Subject: doc 2026/90254 at location land at, Vanguard Processing Equipment, Spa Fields Industrial Estate, Slaithwaite, Huddersfield, HD7 5BB

I understand that this is to review discharge of conditions 9, 11, and 17 of 2021/90605.

**BUILDING ELEVATION 1**  
1 : 100

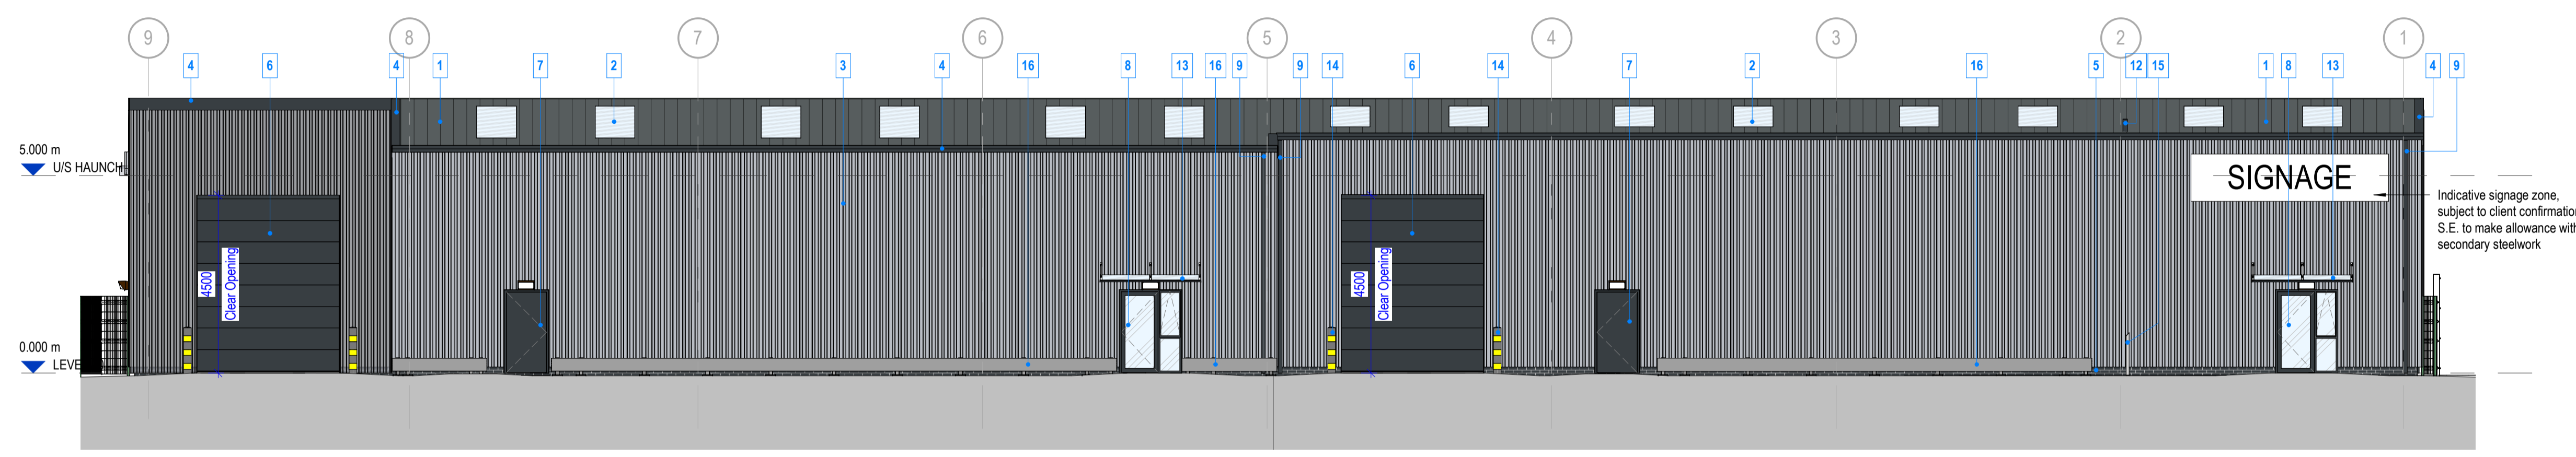
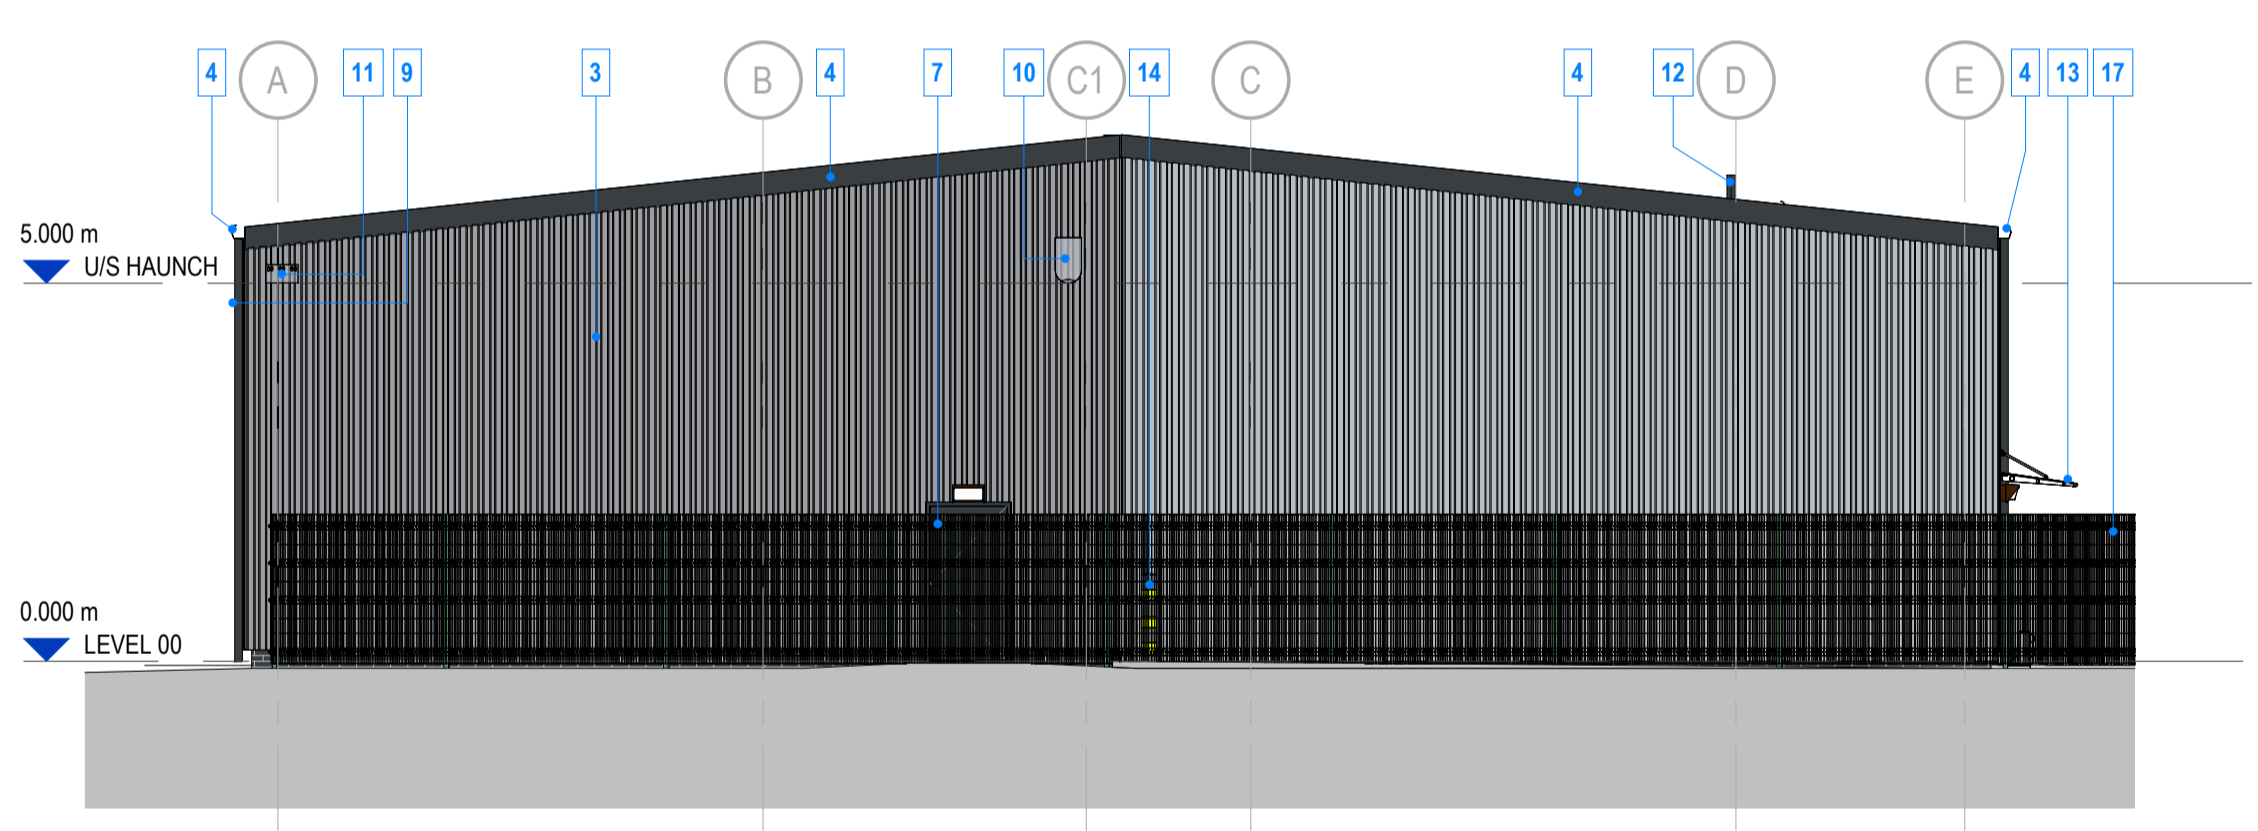
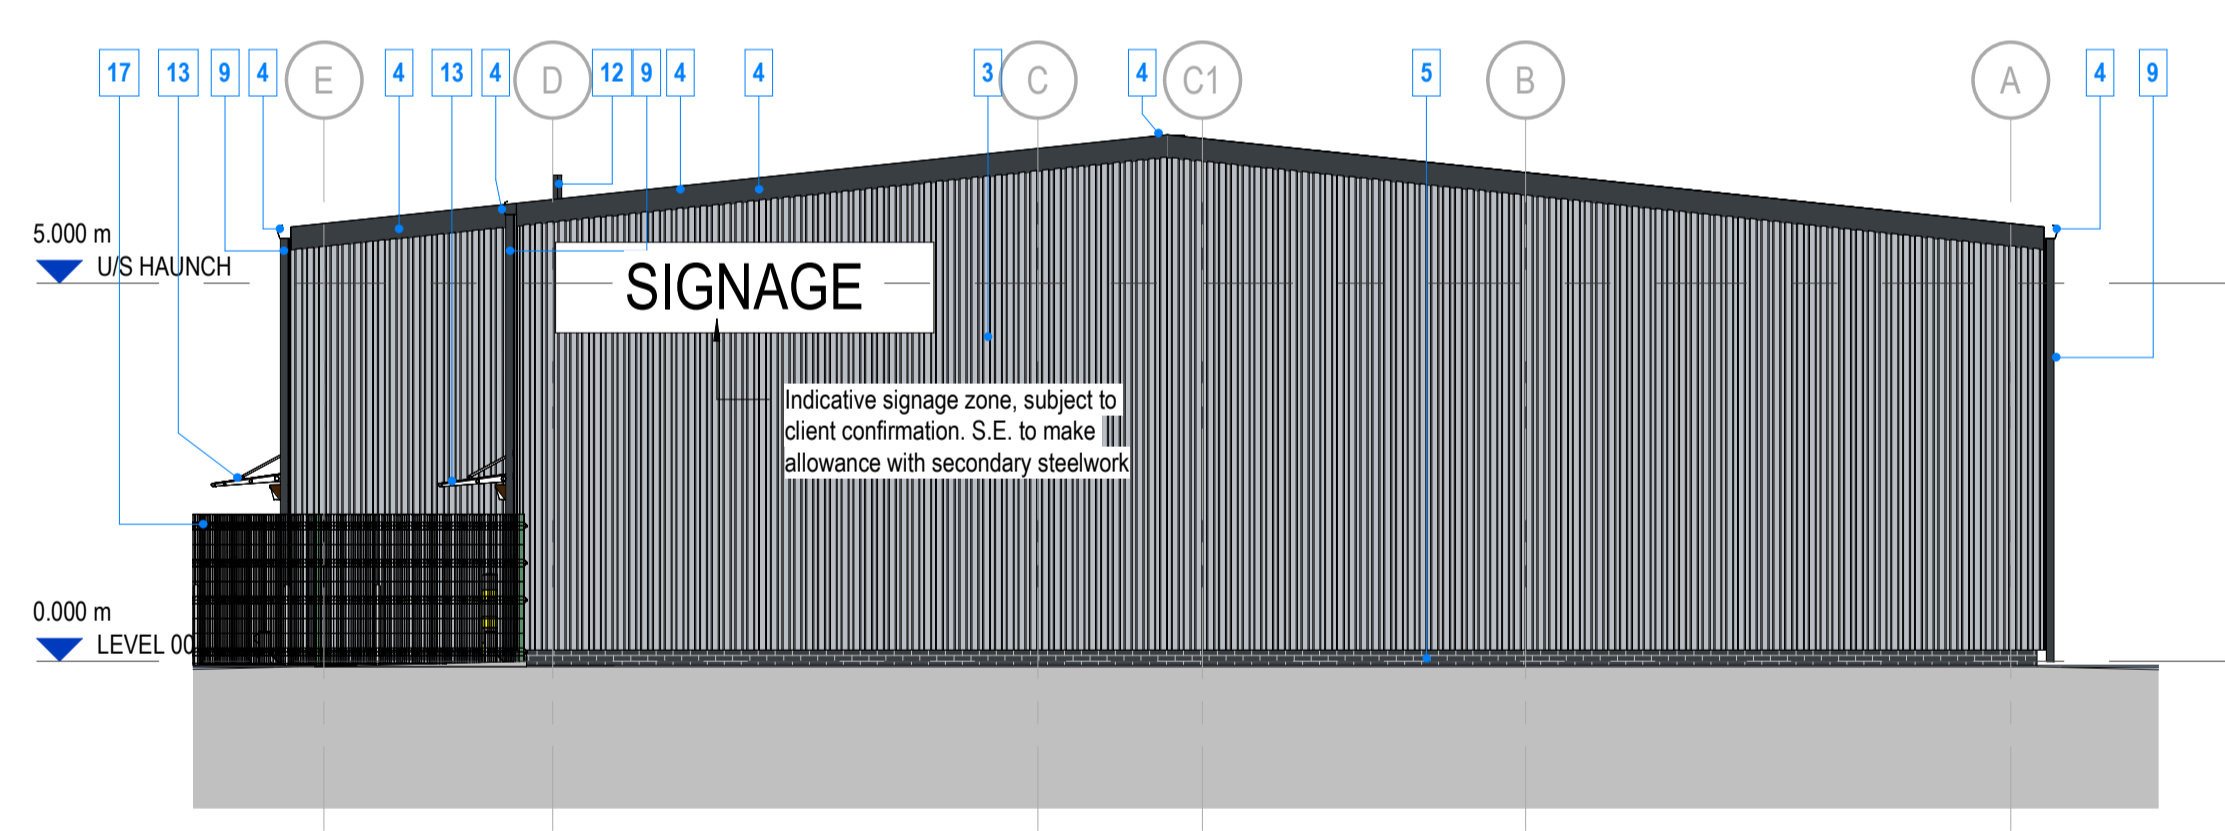
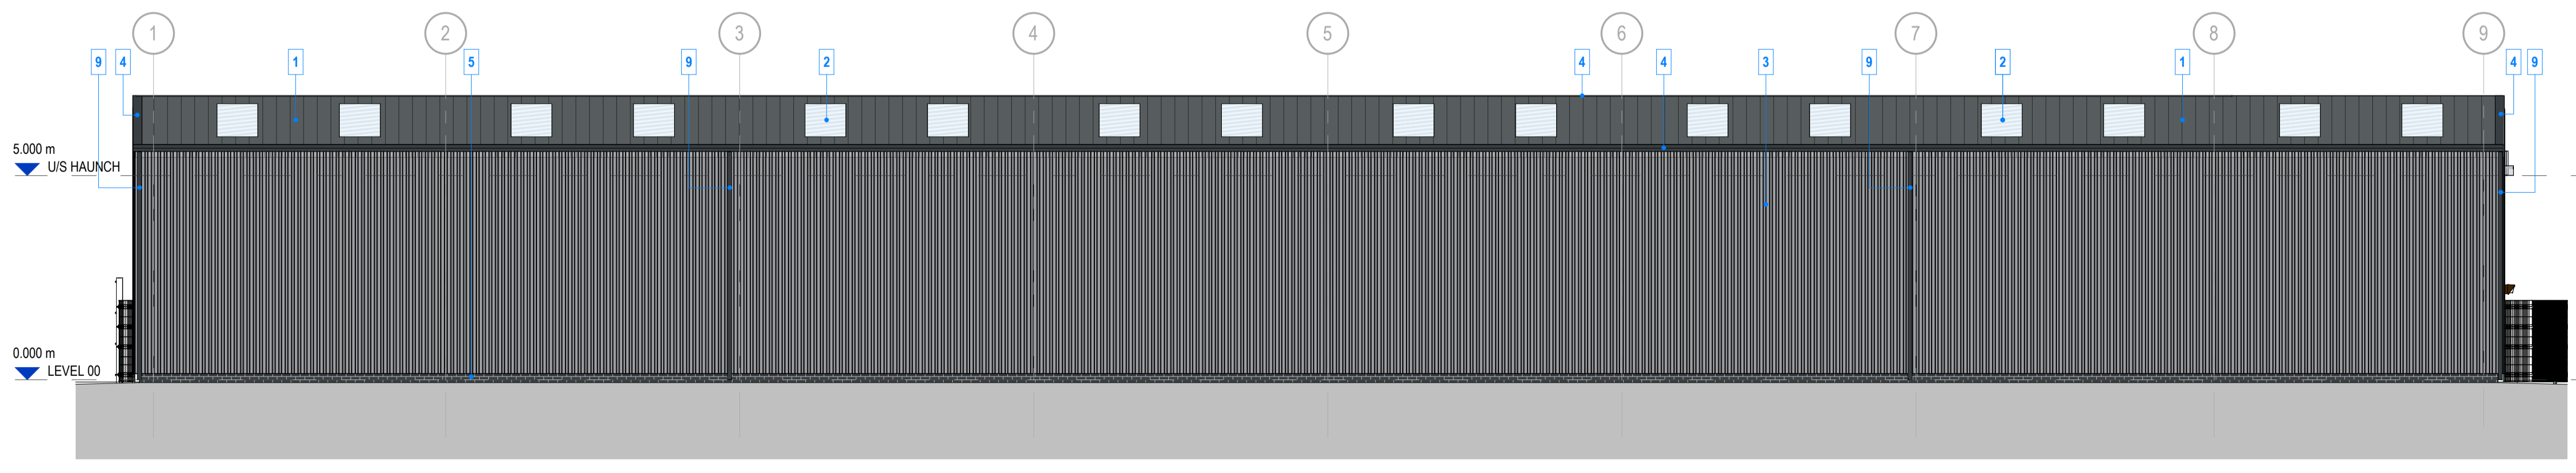
Drawings reviewed to do show . mention bat and bird boxes.

Condition 17 is not yet met.
